Axis J9, Phase 3

I write in response to your email dated 18 February 2022, which set out Officers' views on the proposals.

Figure 5.2: Units 1-3 Facade Treatment (Drawing Reference No. 20019-TP-008 REV C)

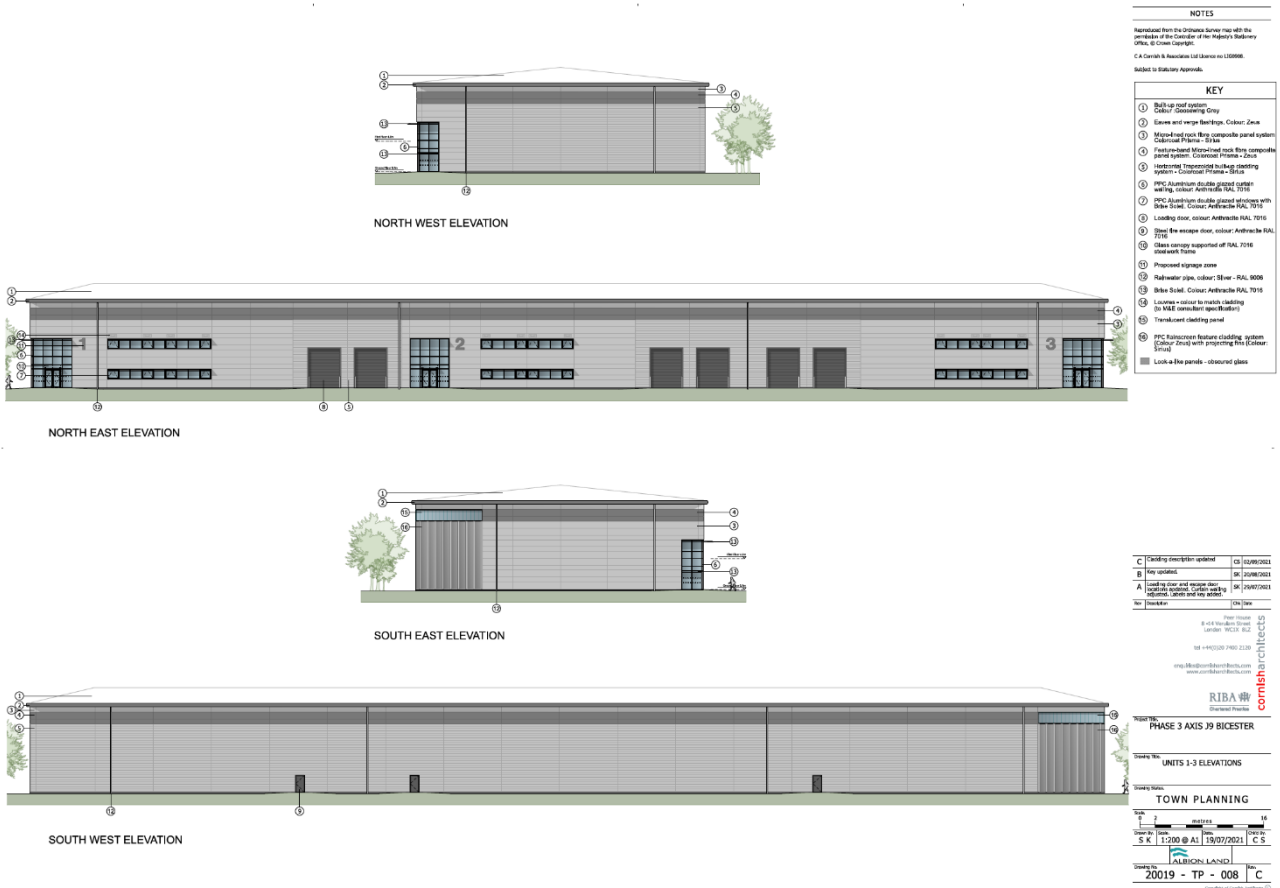
You requested that the rainscreen feature cladding and projecting fins along the southwestern elevation of Unit 1-3 be extended and the proposals have been updated in accordance with this suggestion (see Figure 1.1 and 1.2 for comparison).

Fig. 15 Unit 4 Elevations

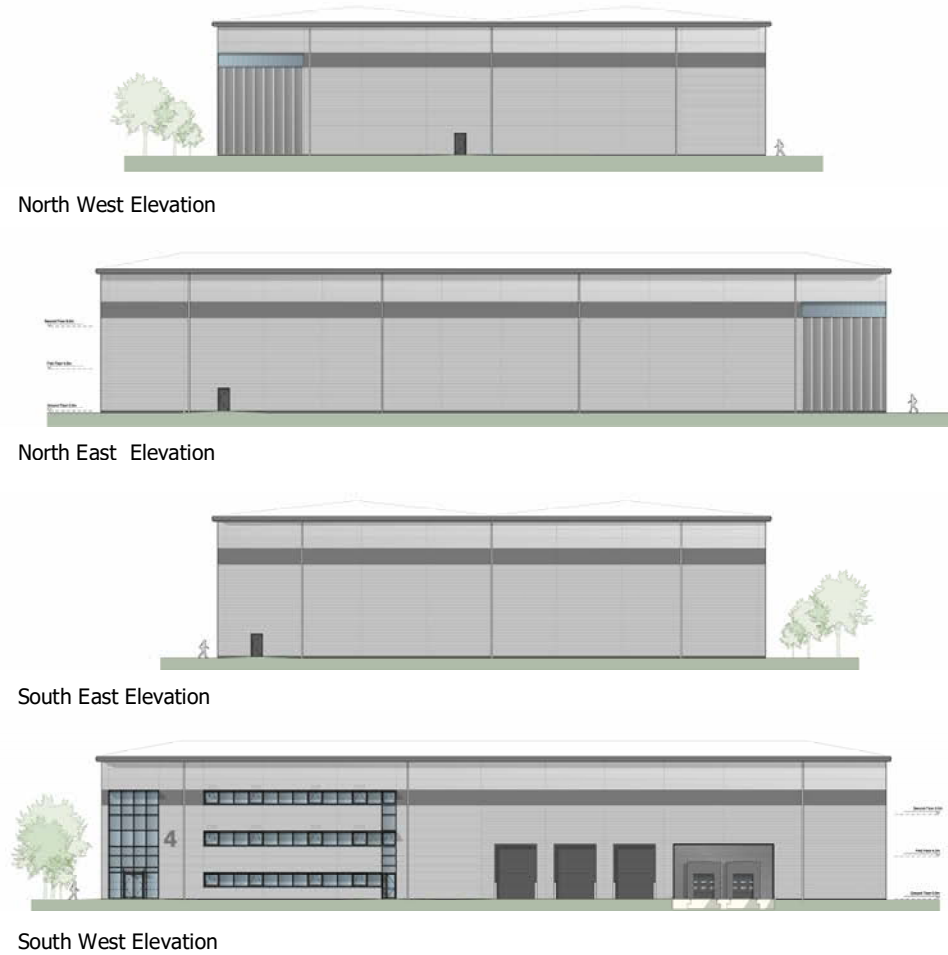
You also requested that the north-eastern elevation of Unit 4 was activated further. Accordingly, the north-eastern elevation of the unit has been updated to incorporate additional feature rainscreen cladding with projecting fins, with glazed panels above (see Figures 1.3 and 1.4 for comparison). This adds substantial additional visual interest to this elevation, in a manner which is wholly consistent with other units within the scheme.
